**RE: Review Comment Responses / Owl Place Commercial  
El Paso County, Colorado**

The purpose of this letter is to respond to review comments provided by Felsburg Holt & Ullevig (FHU) made to the September 2022 version of the Traffic Impact Study and dated November 28, 2022 (2<sup>nd</sup> Review). We have provided detailed responses to the review comments and made revisions to the Traffic Impact Study where applicable. We remain available to discuss further if needed.

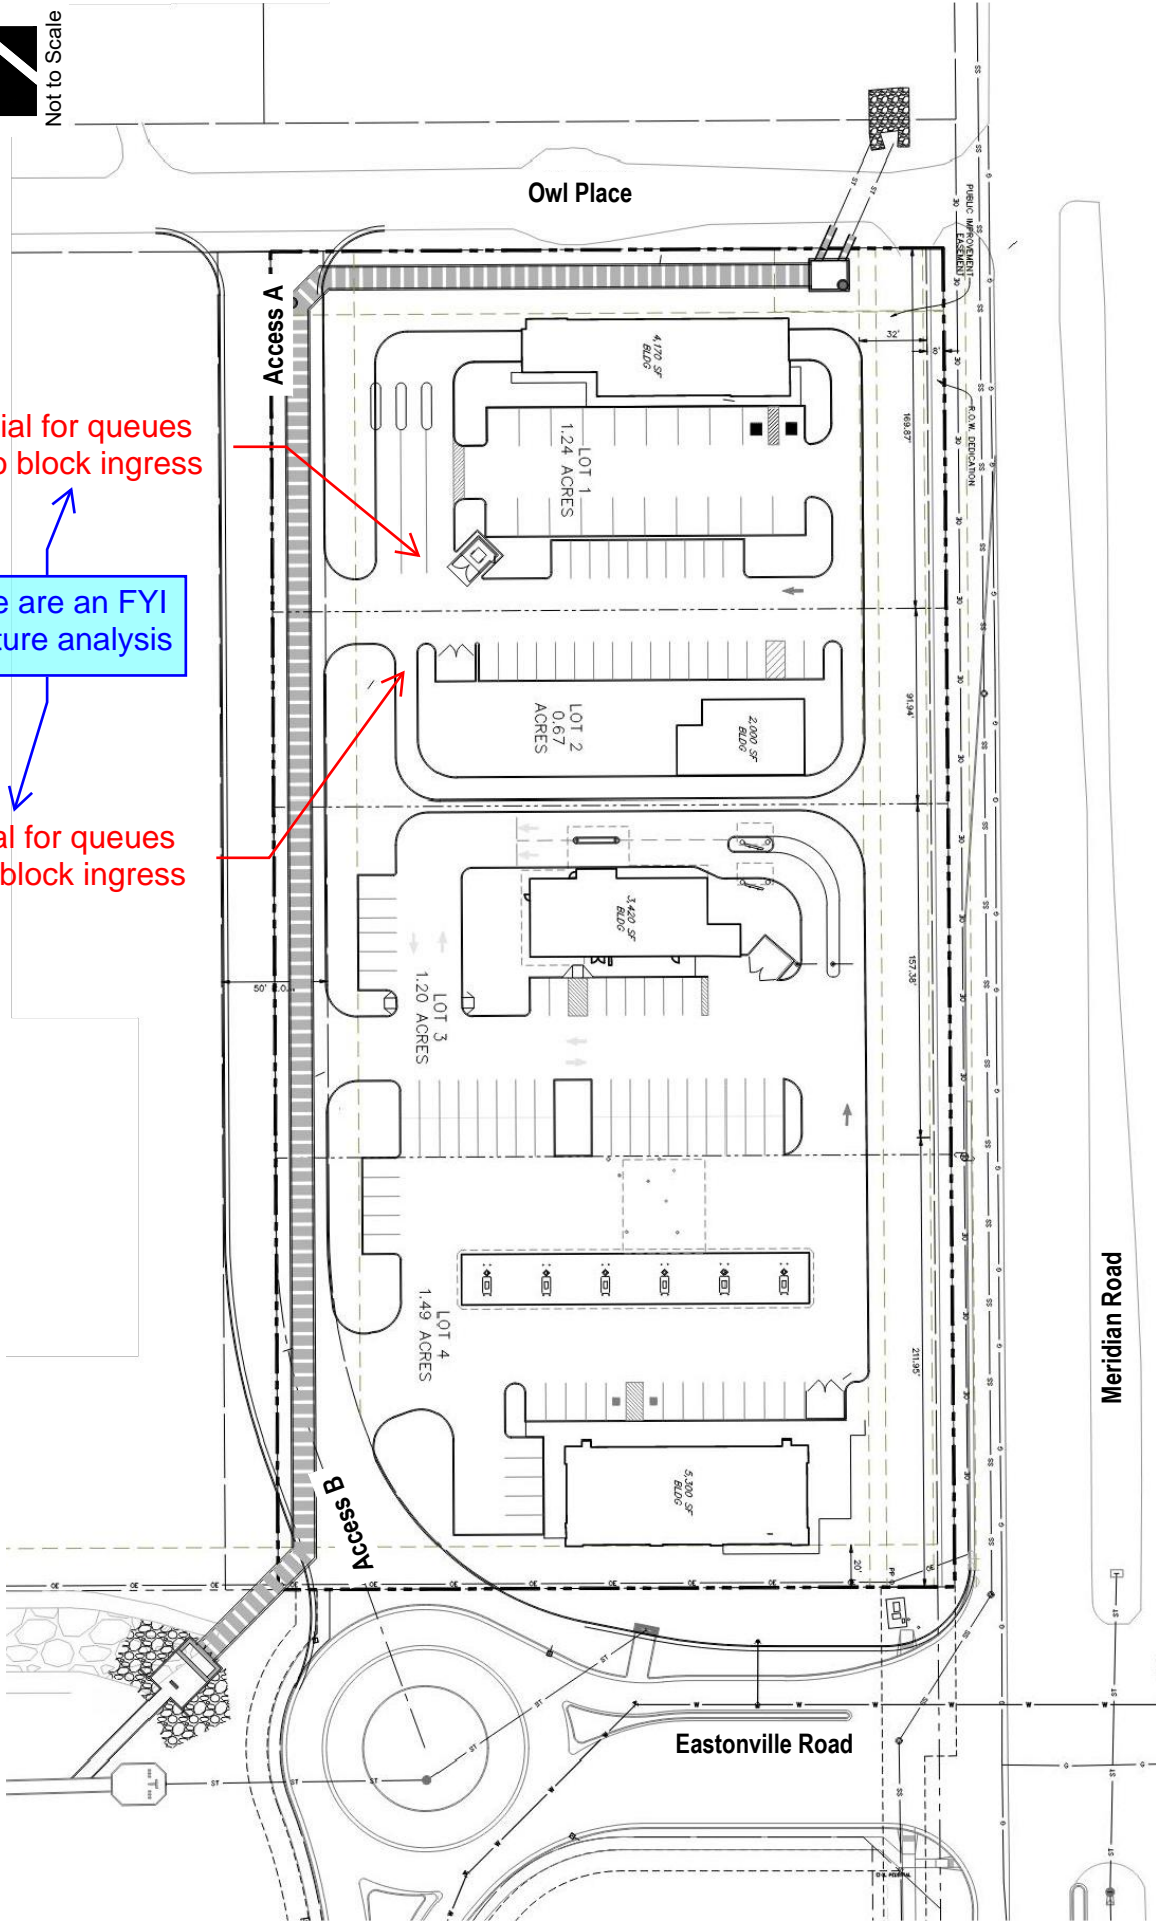
**FHU Technical Comment 1:** Figure 2, the Site Plan, shows that three driveways along the north-south spine roadway are anticipated. This is likely an improvement when compared to the site plan presented in the previous TIS. However, these accesses have not been analyzed for traffic volumes, LOS, or queuing. Potential queuing into the northernmost driveway from Lot 1 or Lot 2 could impact traffic operations at the access road intersection at Owl Place (Access A).

**Comment Response:** Operational analysis of specific lot access locations added to revised TIS.
